WEST SUSSEX COUNTY COUNCIL CONSULTATION

TO:	Arun District Council FAO:Anita Gardner
FROM:	WSCC - Highways Authority
DATE:	26 April 2022
LOCATION:	Land West Of Yapton Lane Walberton
SUBJECT:	WA/2/22/OUT Outline planning application with all matters reserved, other than means of access, for the construction of up to 48 dwellings (30% affordable homes) and dental/doctors' surgery (Use Class E (e)). This application may affect the setting of a listed building & may affect the Walberton Village Conservation Area. Amendment received on 13th April 2022.
DATE OF SITE VISIT:	n/a
RECOMMENDATION:	No Objection
S106 CONTRIBUTION TOTAL:	n/a

Figure 3: Public Rights of Way

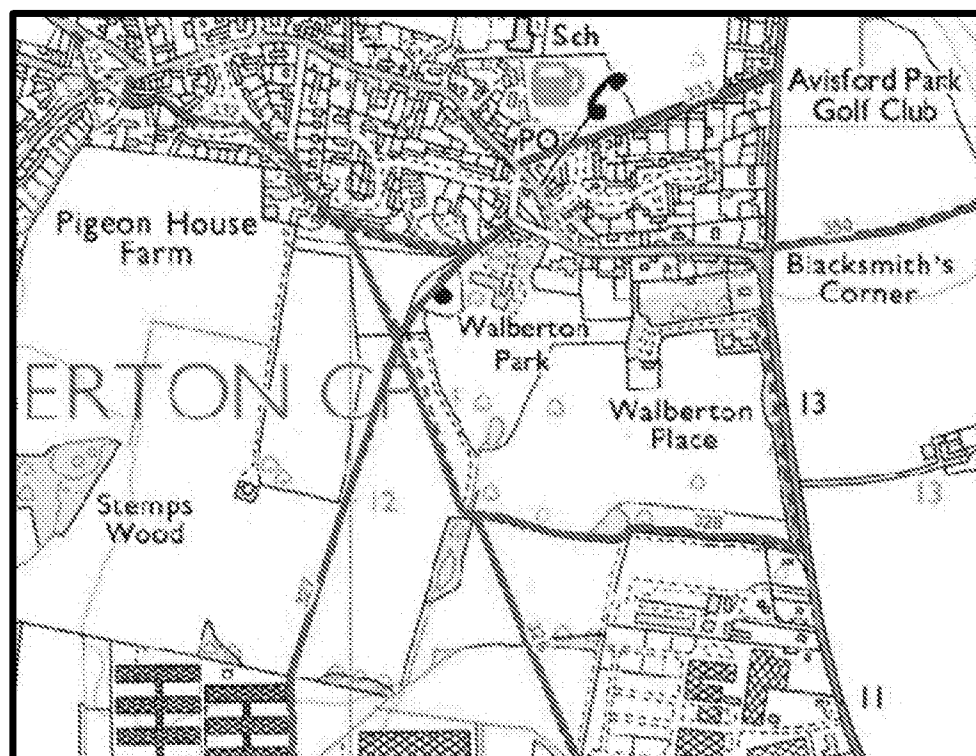
The only matter raised within this section was in respects of the ability to upgrade permissive right of way P23. This link is quite fundamental as without it, there is no means of pedestrians accessing Walberton village to the north other than to walk in the carriageway along Yapton Lane. Walking in the carriageway on Yapton Lane in this location would not be considered appropriate.

In terms of the potential improvements, no further information has been included and as such it still is not apparent what is achievable or whether this

could facilitate cycling as previously recommended. It is accepted that the permissive route lies land forming part of this application, and as such no 3rd party consents would be required to deliver works to provide an improved route to the north. It's therefore recommended that a scheme of improvements is secured by condition (rather than a contribution to allow WSCC to undertake works as suggested within the Addendum TS). This scheme should seek to provide a route with improved width and surfacing to ensure this is usable all year round.

No part of the development shall be first occupied until improvements have been undertaken to Permissive Right of Way P23 in accordance with plans and details, which shall include a construction specification for the proposed surfacing works have been submitted to and approved in writing by the Local Planning Authority.
